Development Facilitation Team (DFT) – Review Comments

Project No: PR-2023-008999

Application For: SD-2024-00013-BULK LAND PLAT

REQUEST: BULK LAND PLAT INNOVATION PARK III TRACTS A-N

**BULK LAND PLAT**  
**INNOVATION PARK III**  
**TRACTS A-N**  
(BEING A REPLAT OF TRACT 18 ARTISTE)  
**CITY OF ALBUQUERQUE**  
**BERNALILLO COUNTY, NEW MEXICO**  
**JANUARY, 2024**

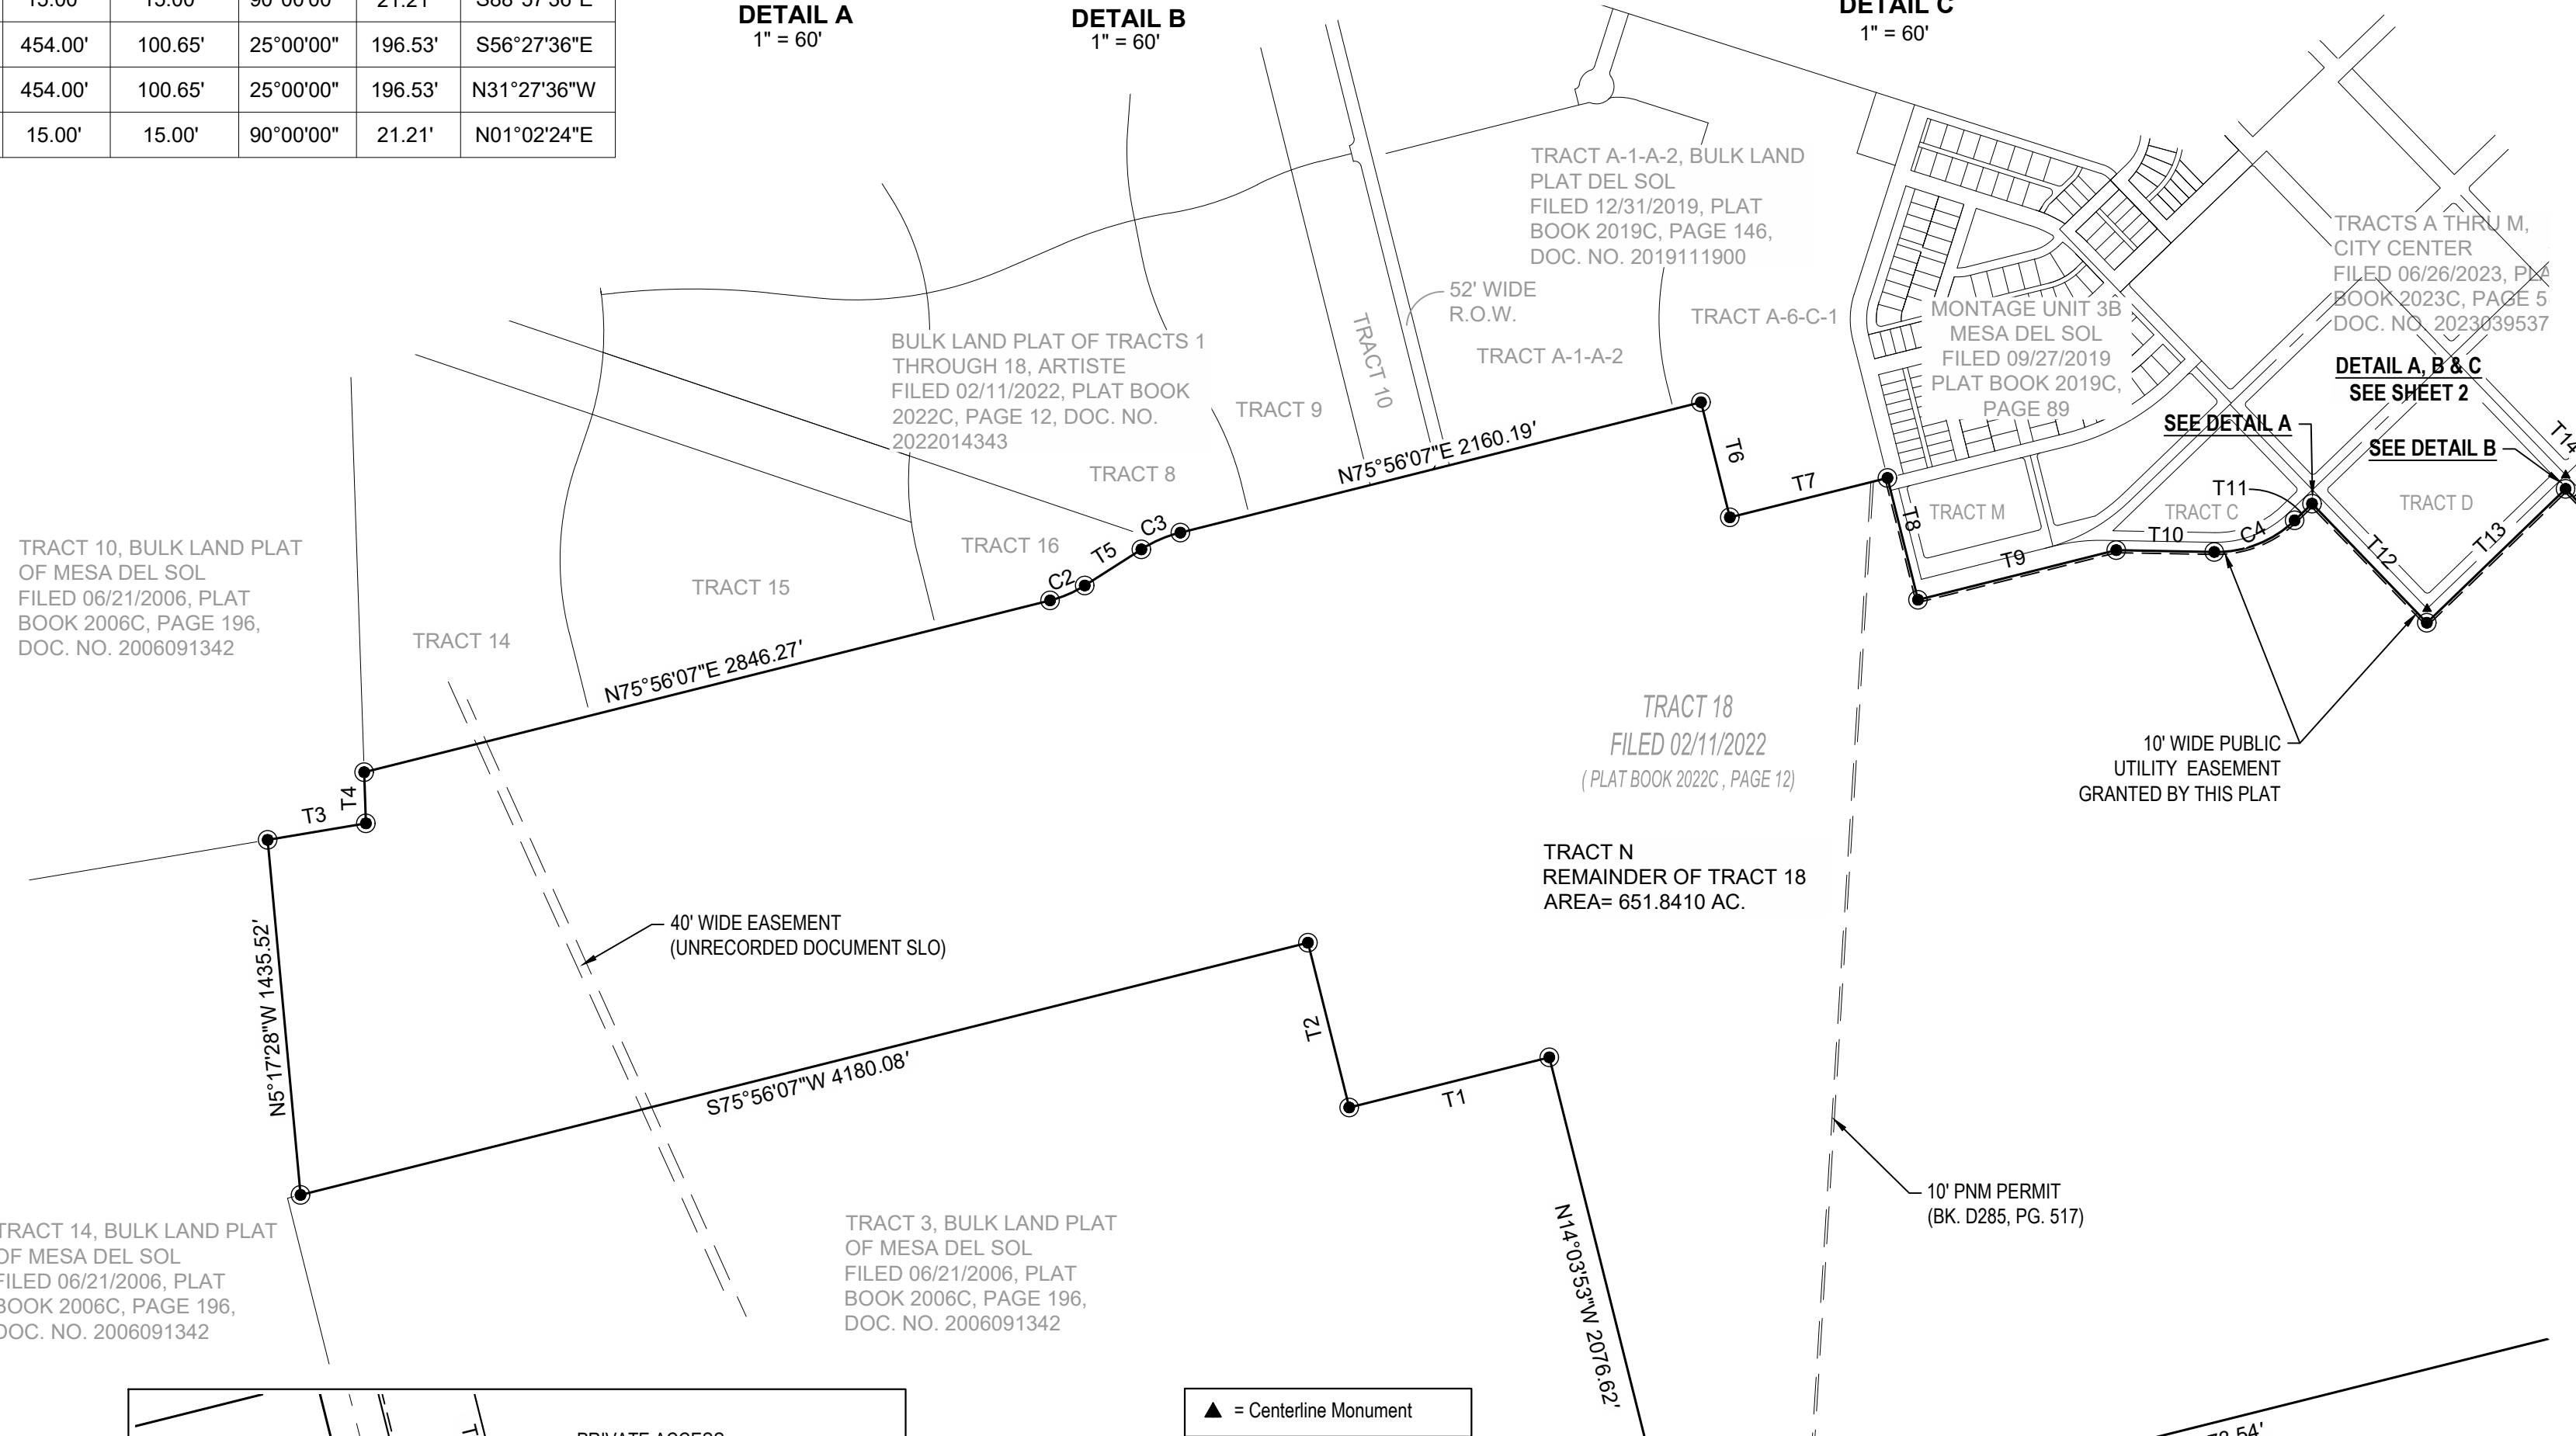
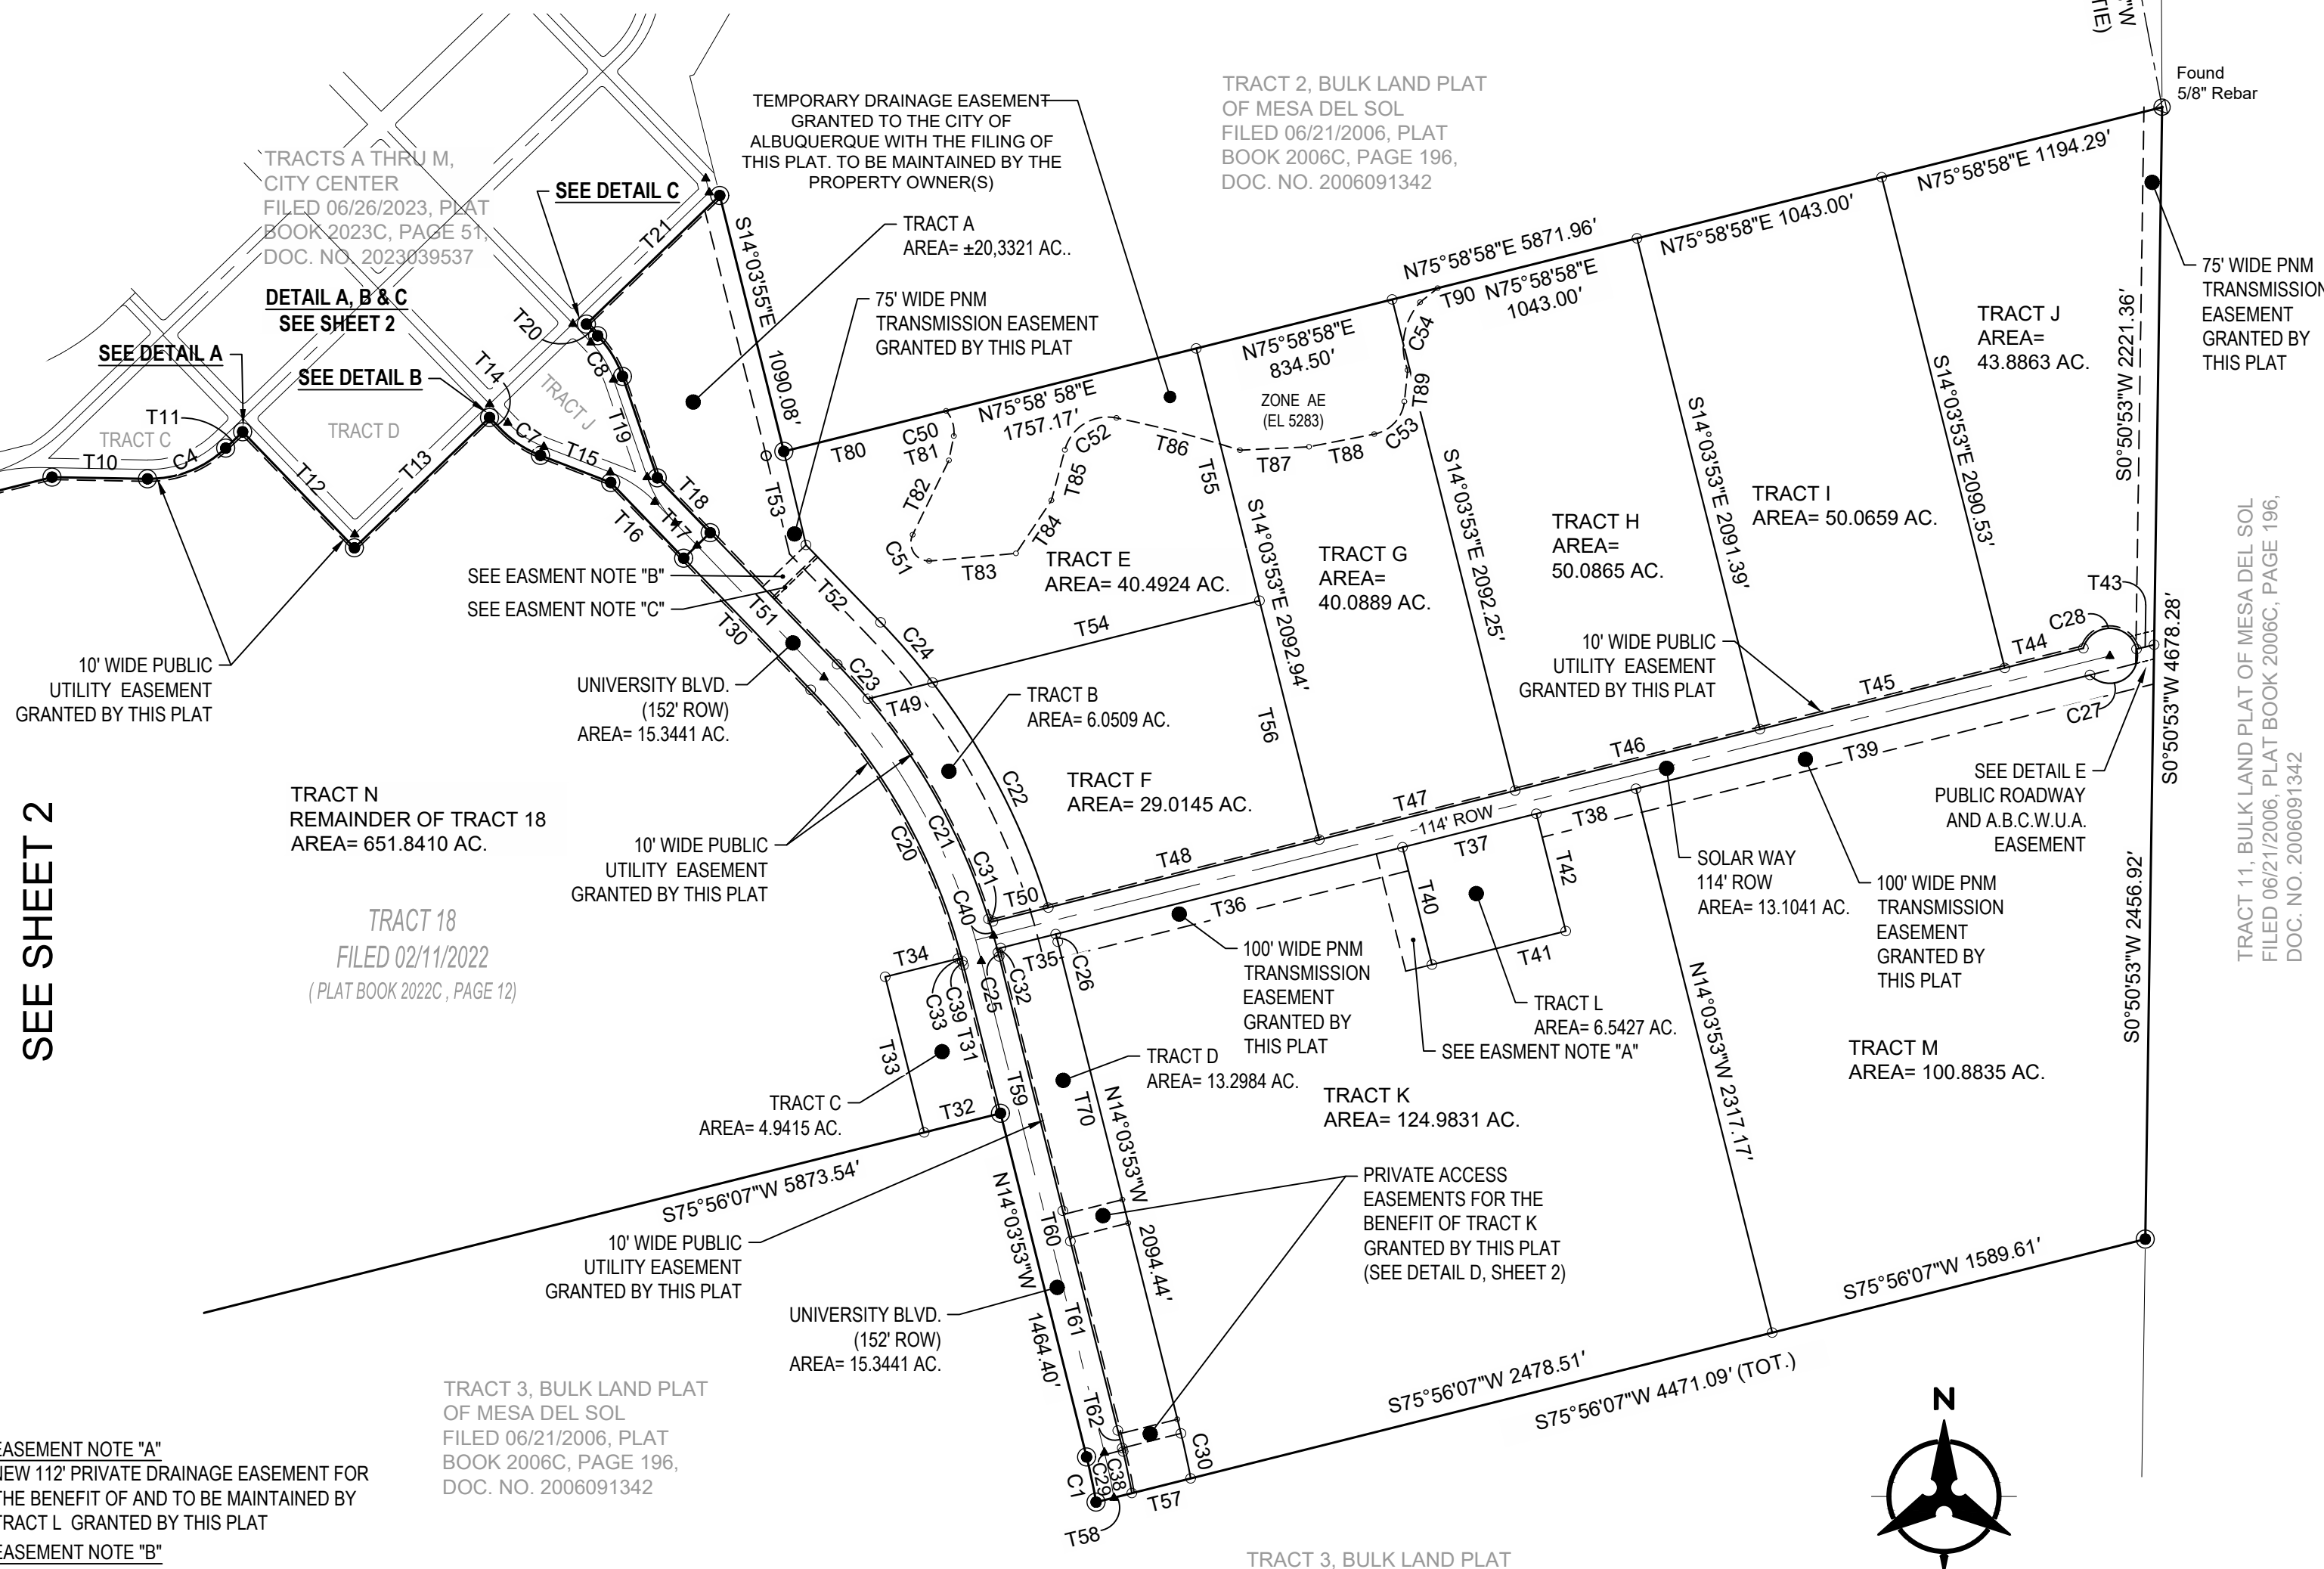
1. How will Tract 11, get service?
 - a. Please provide a public water and public sanitary sewer easement across Tract M or J to make the connection.
